Stephen O'Donoghue
Senior Planner
Mining and Industry Projects
NSW Department of Planning & Infrastructure

Our ref ER20893

Cobbora Coal Project – Response to PAC Recommendations and Revised Preferred Project Report (10_0001)

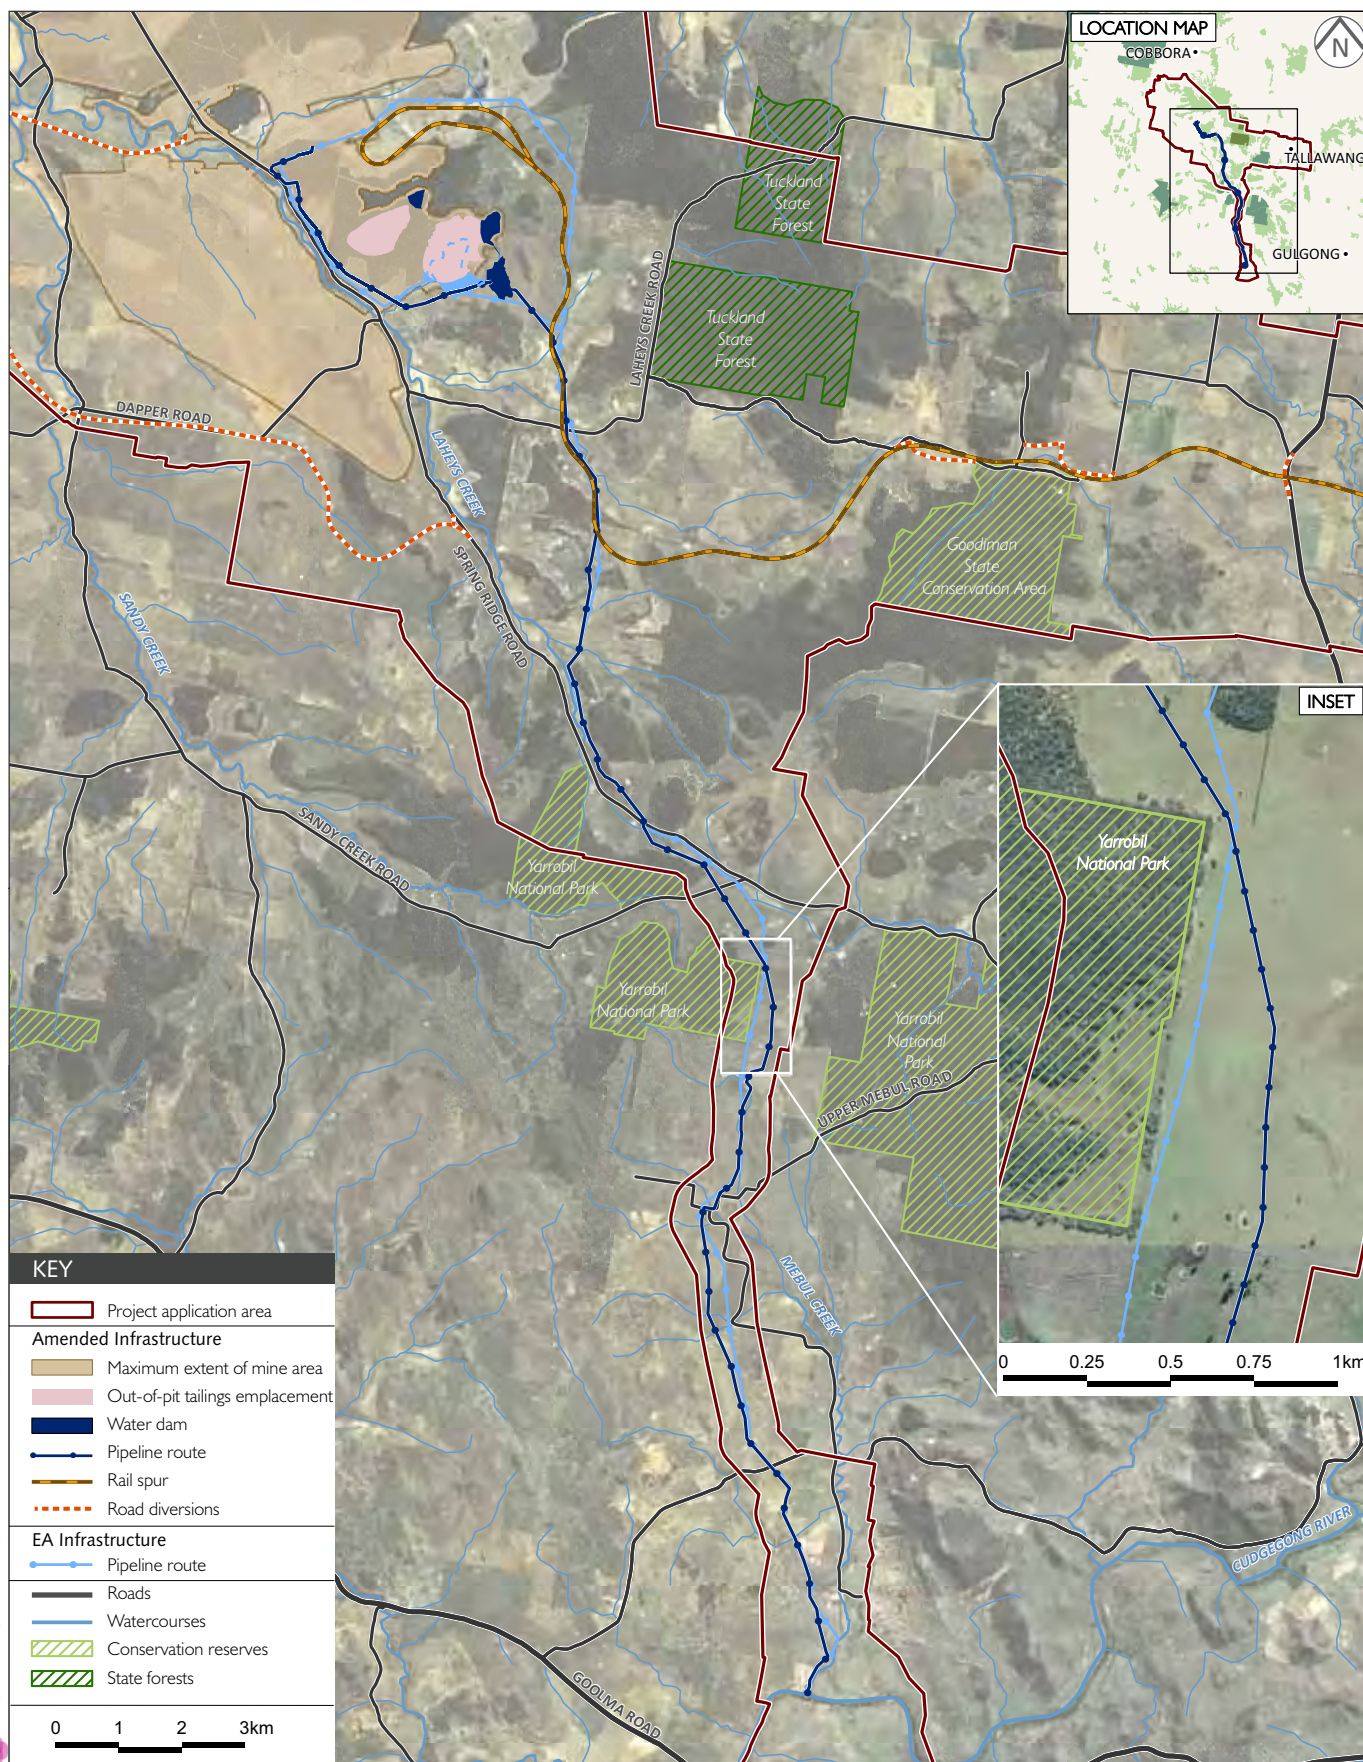
- The proposal to construct a diversion around the top water level of the Raw Water Dam will result in a realignment of the current watercourse and establish the Raw Water Dam as a turkey's nest storage. Conceptually this will limit the potential for surface runoff capture to within the storage itself and maintain the flow of runoff downstream from upstream sources. The NSW Office of Water advises this proposal may alleviate the need to hold licensed entitlement for the capacity of the Raw Water Dam. This will need to be confirmed based on detailed design to achieve the objectives proposed. The design and mitigation of impacts from construction of the Raw Water Dam will also need to be considered in this proposal. It is recommended the detail for both the raw water dam and clean water diversion be addressed within the Construction Environmental Management Plan and be consistent with the NSW Office of Water's Guidelines for Controlled Activities on Waterfront Land (2012).
